DEVIATION REQUEST AND DECISION FORM

Project Name :	Silverado Ranch, Filing 2
Schedule No.(s) :	3516000001
Legal Description :	N2 SEC 16-15-63 EX TH PT PLATTED TO SILVERADO RANCH FILING NO 1

LSC RESPONSES TO EPC Deviation Redlines (This deviation is now called "Deviation No. 1")

Deviation Request No. 1

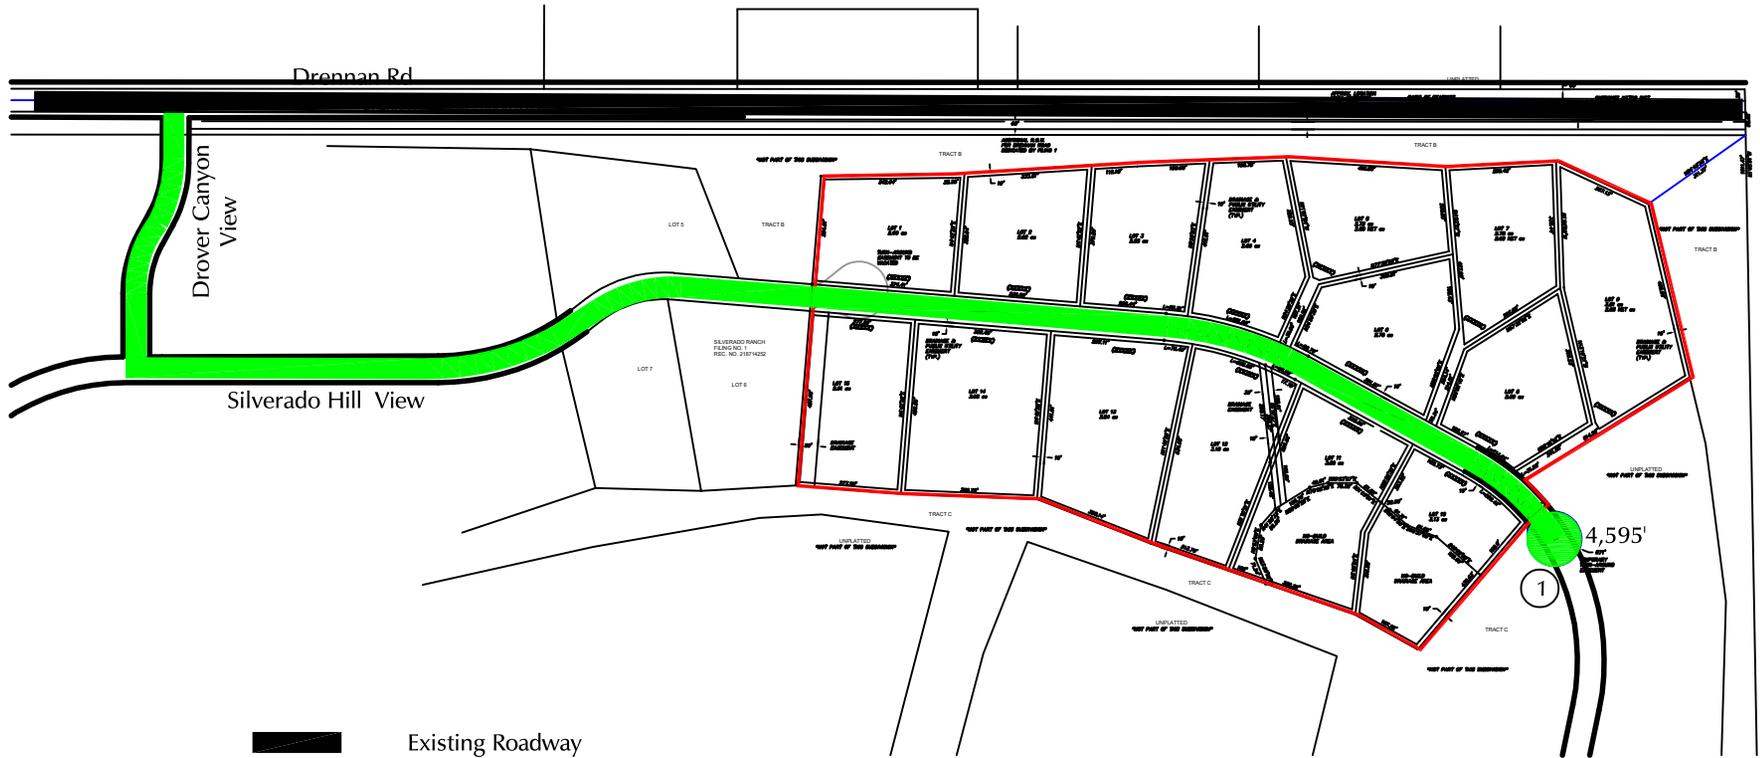
A temporary cul-de-sacs is proposed, so it should be 2.3.8.C. The maximum length for the temporary cul-de-sacs is 600ft. Please revise. Also, please indicate which type of temporary cul-de-sacs for this project (Within the Plat, Outside the Plat of a Phased Development or on Property not Owned by the Current Developer).

LSC Response: Modified as requested.
